CITY OF ALBUQUERQUE

July 21, 2016

**RE: Coordinated Vision, Inc
Grading and Drainage Plan
Engineer's Stamp Date 6-21-2016 (File:D16D002G)**

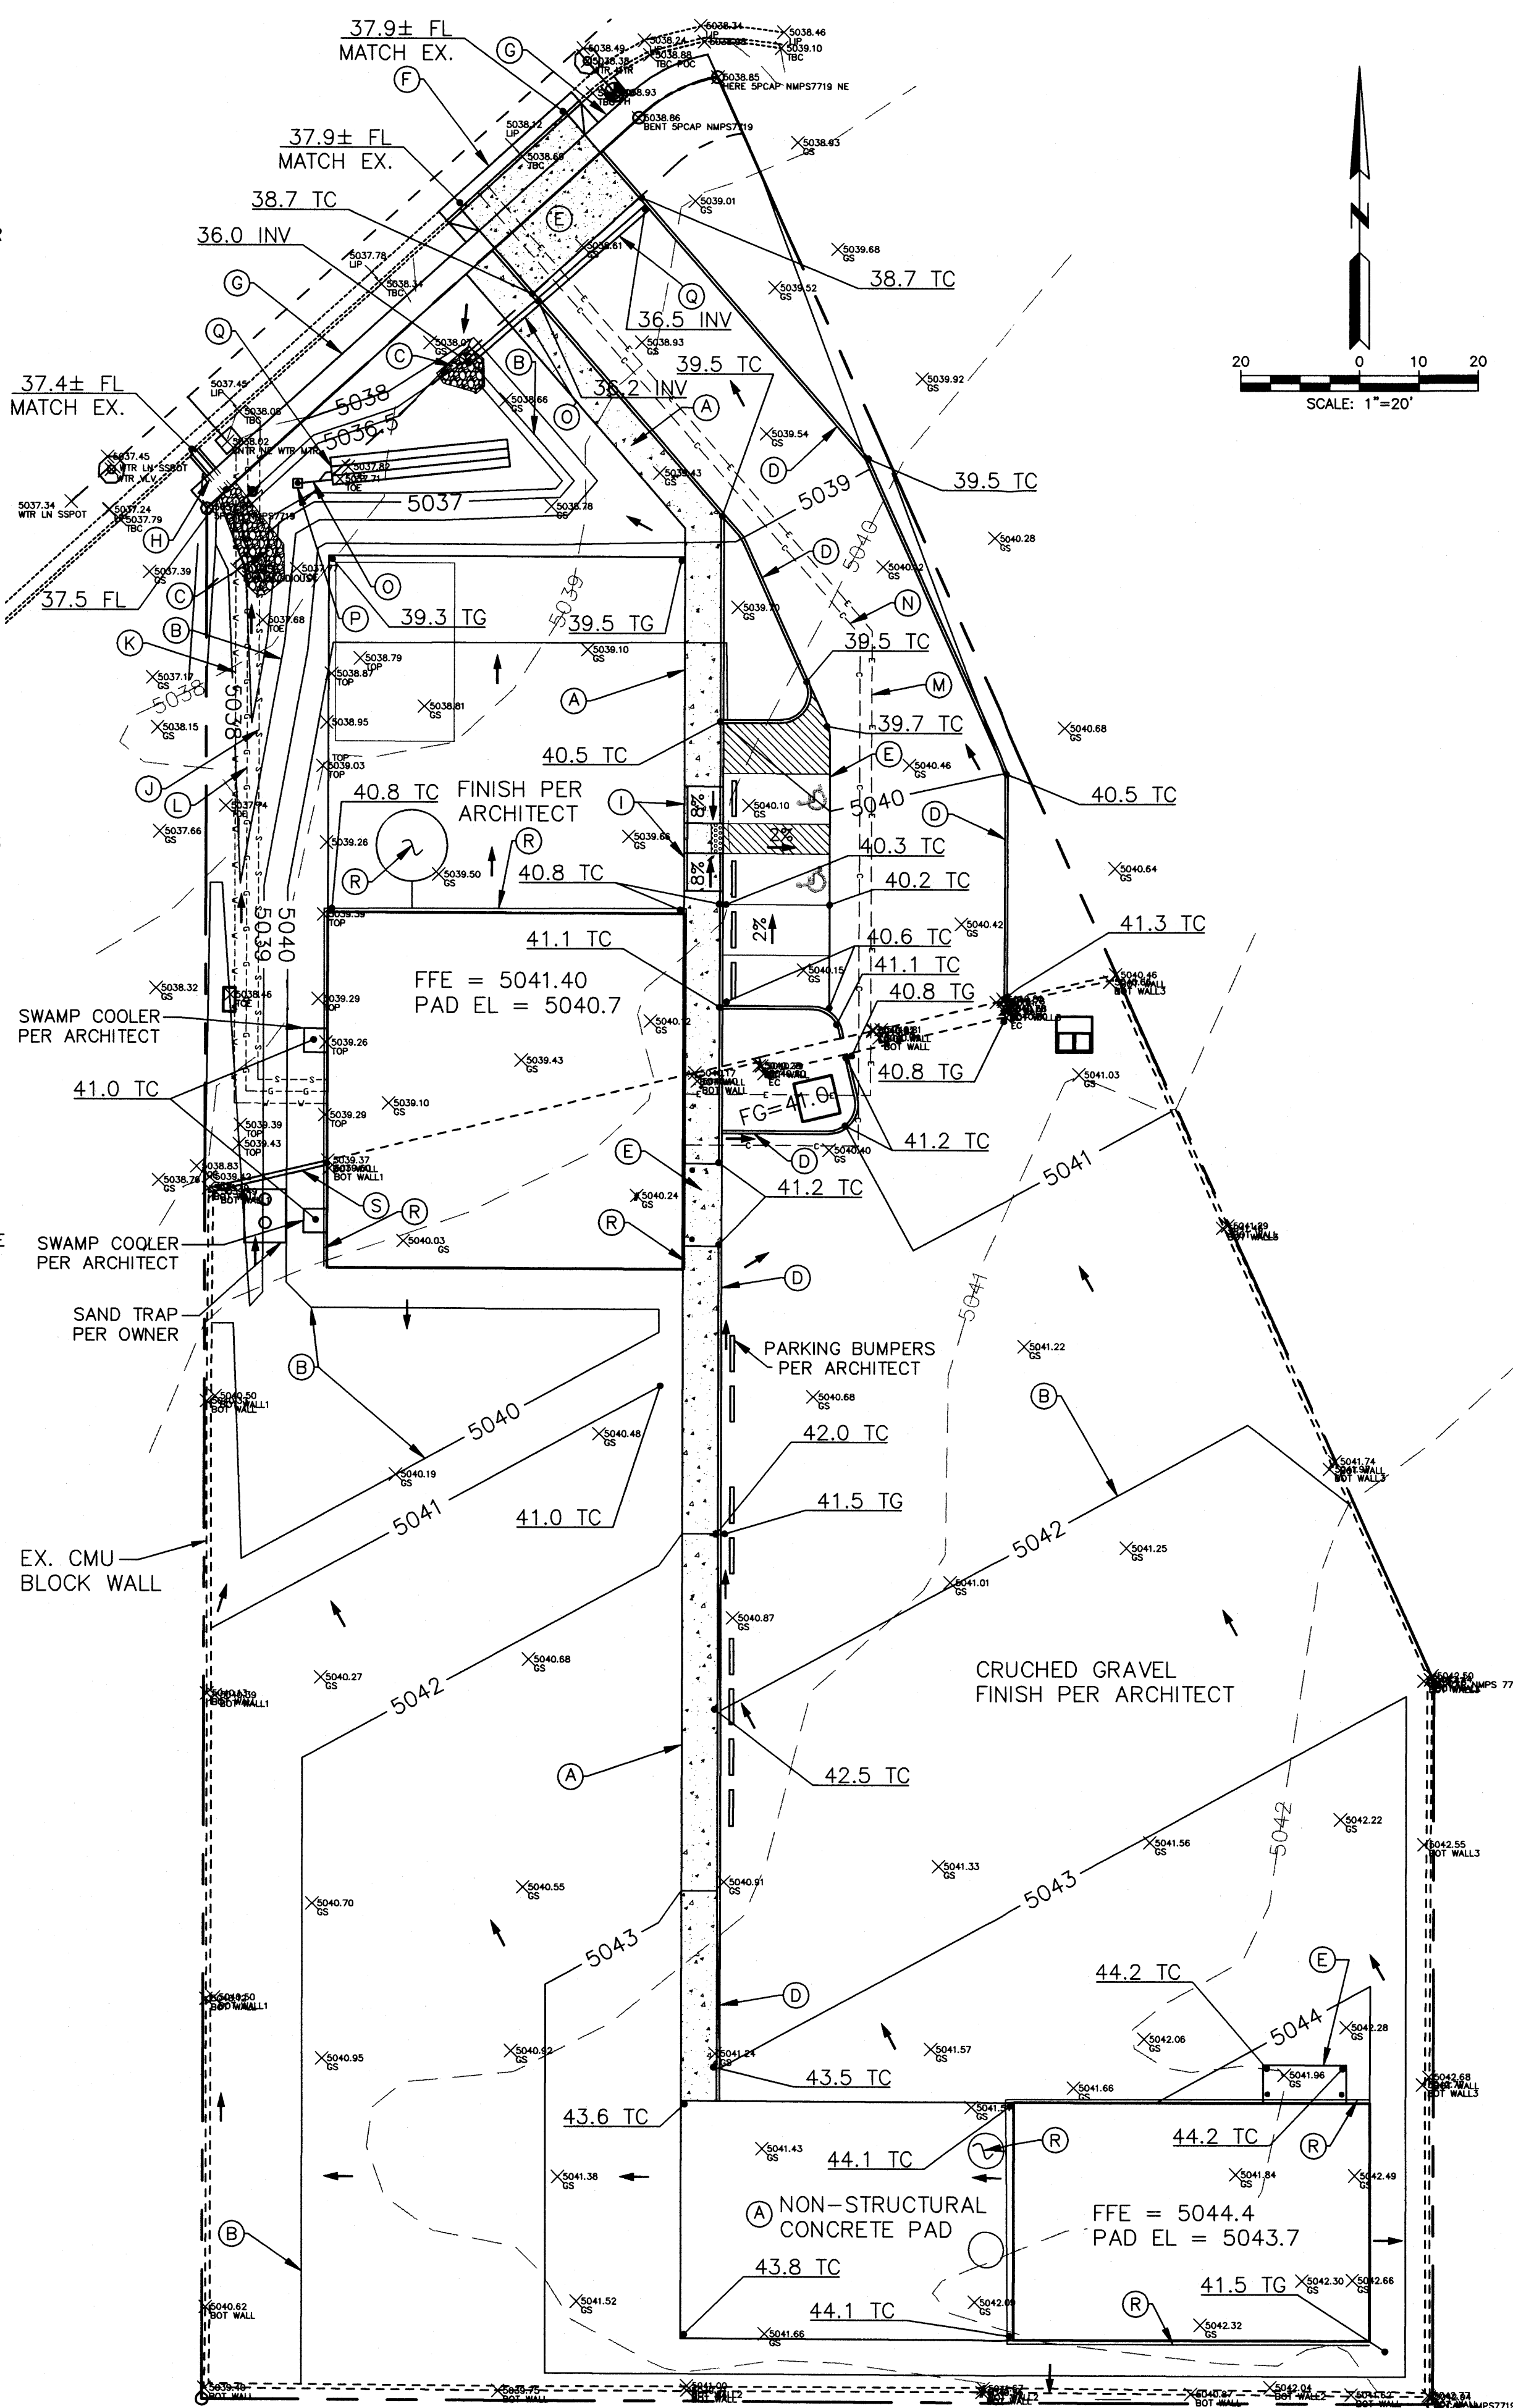
- The construction of the sidewalk in the Right of Way must include a depressed landscape buffer as shown on the revised Standard Drawings 2405A and B.
